From: Craig Milligan <Craig.Milligan@arun.gov.uk>
Sent: 18 November 2020 15:28
To: Planning.Responses <Planning.Responses@arun.gov.uk>; Anita Gardner <Anita.Gardner@arun.gov.uk>
Subject: 15 Beach Road, Littlehampton, BN17 5HZ- LU/295/20/PL

Planning Application Reference: LU/295/20/PL

Address: 15 Beach Road, Littlehampton, BN17 5HZ

Proposal: Full planning application incorporating permitted change of use of part of existing office (A2 Professional & Financial Services) & use to form 2 No. dwellings (C3 Dwelling houses) on the two upper floors (resubmission following LU/107/20/PL). This site is in CIL Zone 4 (Zero Rated) as flats

SCALE / 1:100 @ A3
DATE / 30.03.2020
DWG. NO / 080616/TP.02.REV. 'C'

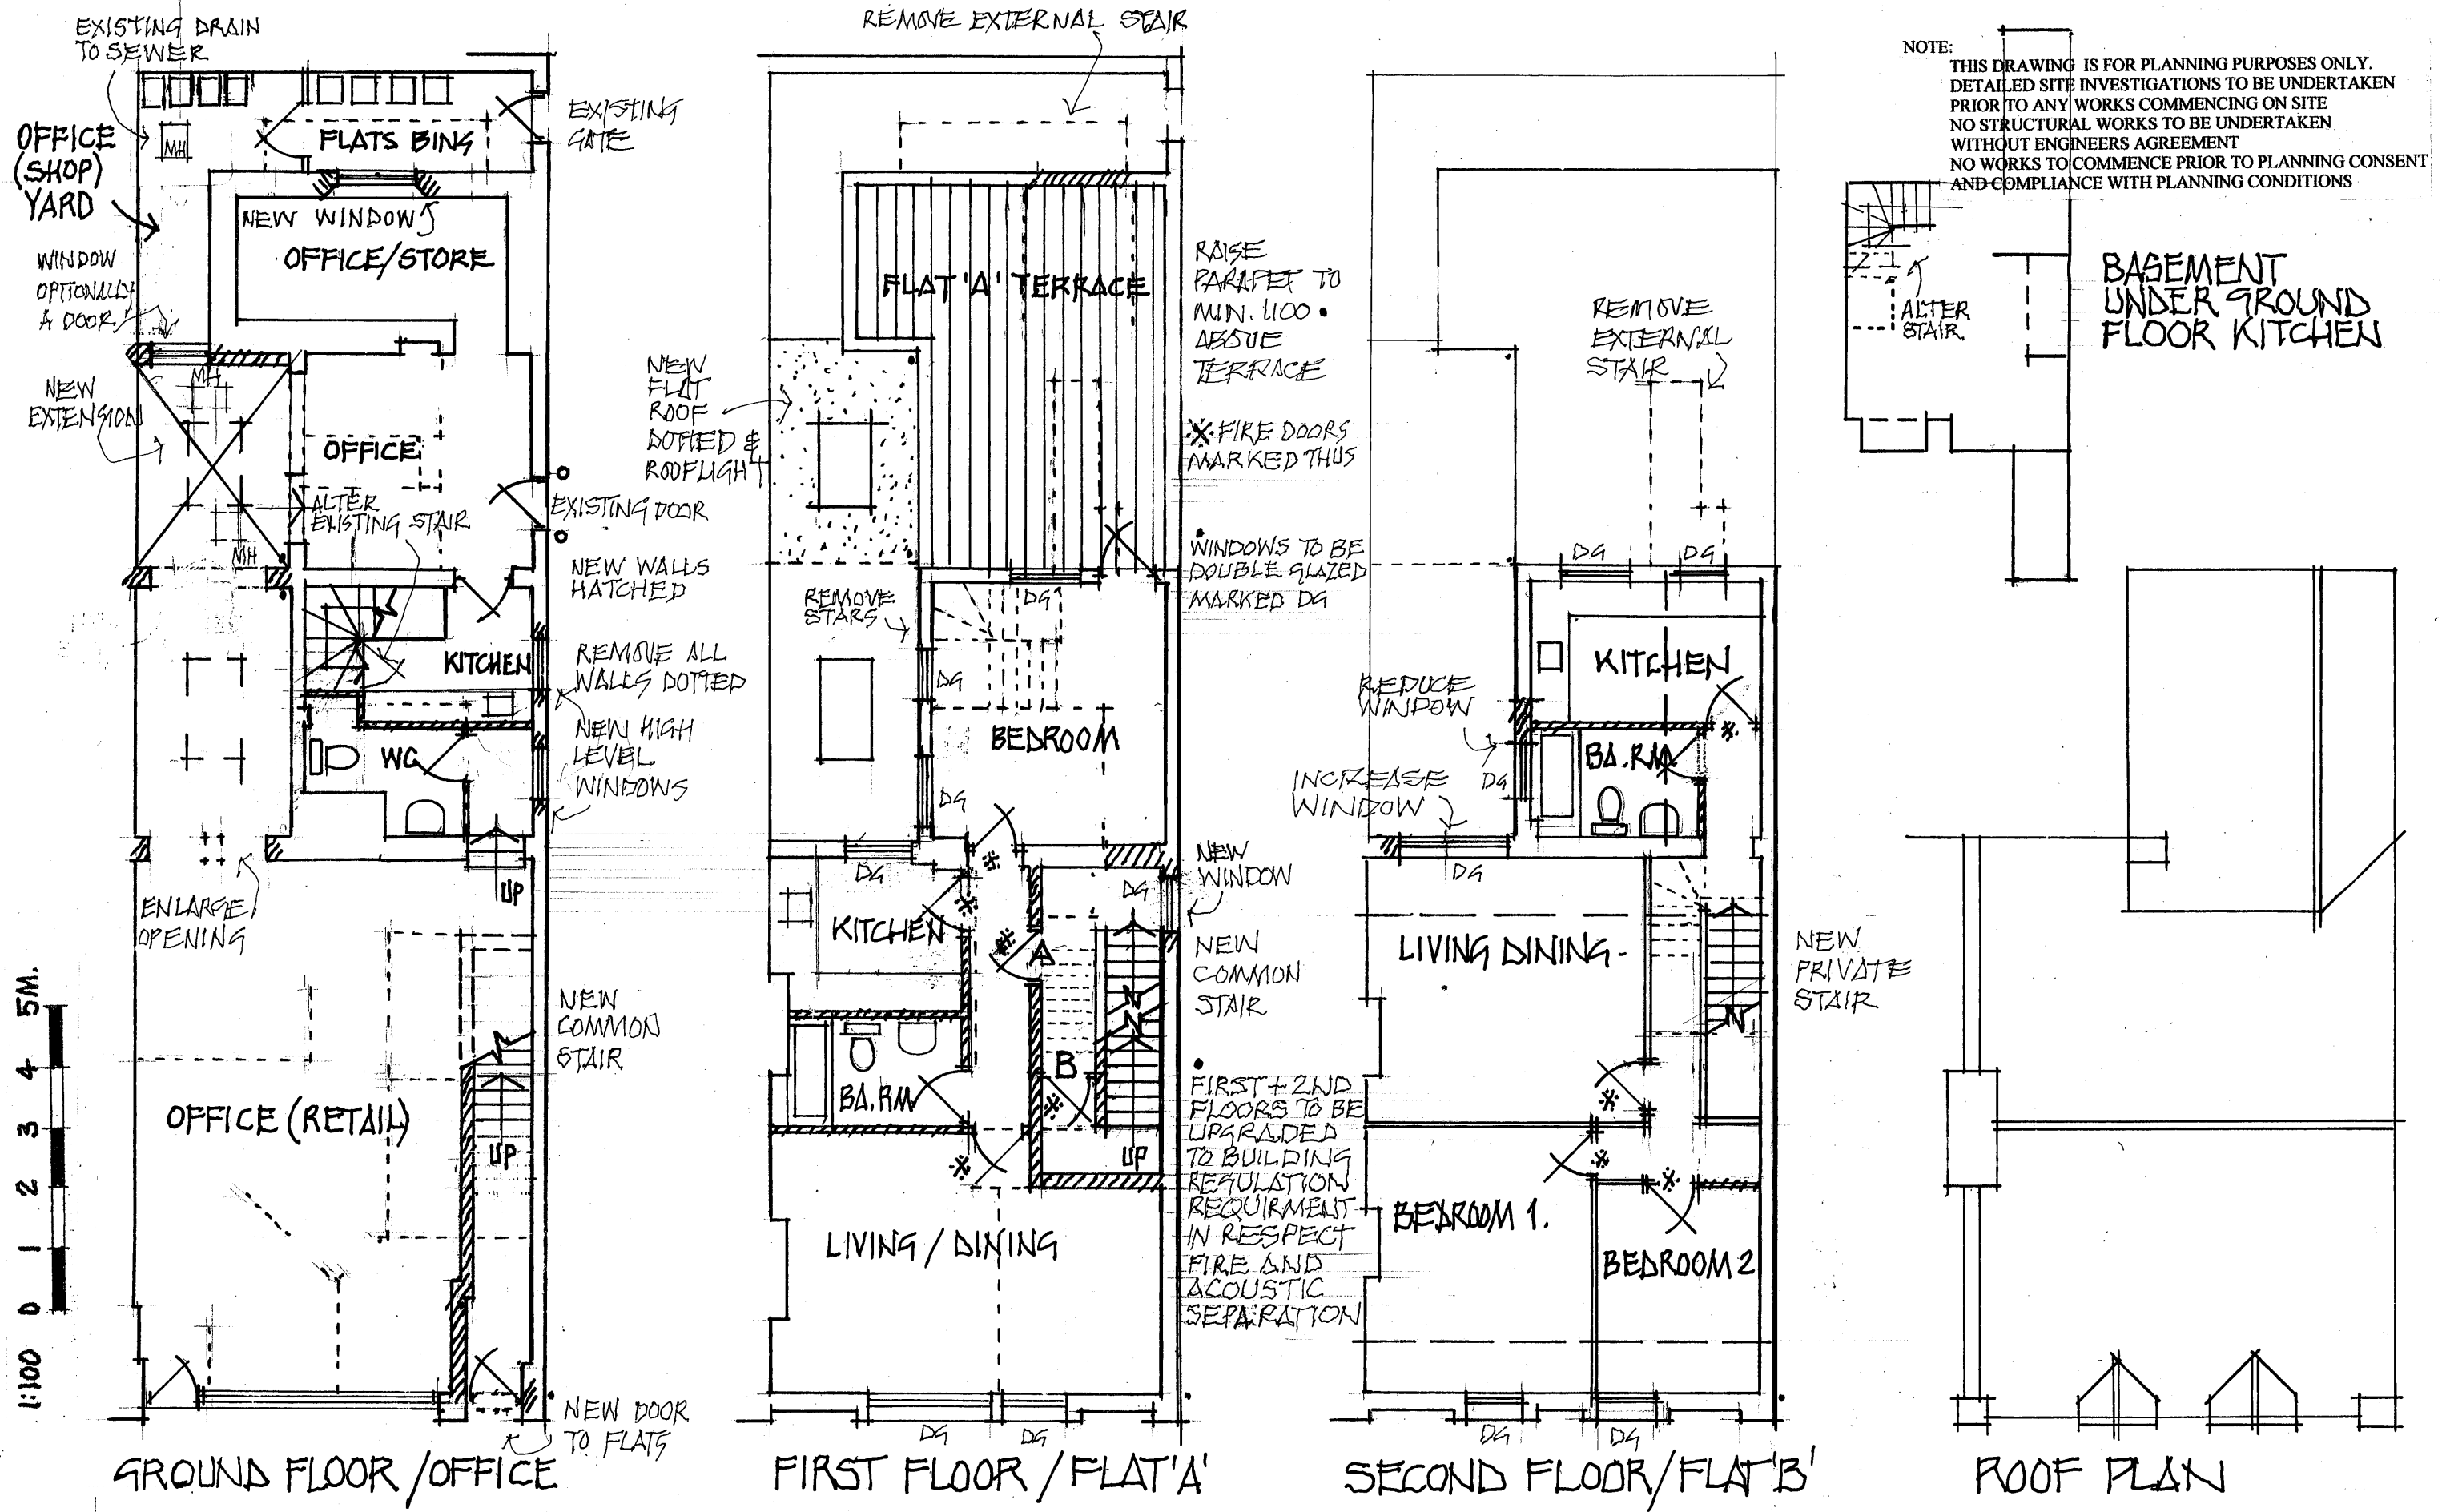
I have noted that the proposed layout of the 2 self-contained flats is arranged such that bedrooms are vertically adjacent to living rooms and Kitchens (bedroom in Flat A is directly below kitchen in Flat B, bedrooms in Flat B are directly above living room in flat A), it is therefore recommended that uprated acoustic measures are required in the floors/ceiling between residential units to mitigate against noise transfer. As the ground floor use is to remain commercial, it is also appropriate to install uprated acoustic insulation to protect the residential usage from noise transfer. I therefore recommend the following condition be attached to any permission granted:

- The sound insulation of the floor / ceiling between the ground and first floor; and the sound insulation of the floor / ceiling between the first and second floors shall achieve a minimum airborne sound insulation value of 50 dB ($D_{nT,w} + C_{tr}$). Before the residential unit is occupied, a test shall be undertaken by a competent acoustician and submitted to the Local Planning Authority to demonstrate compliance with this level.
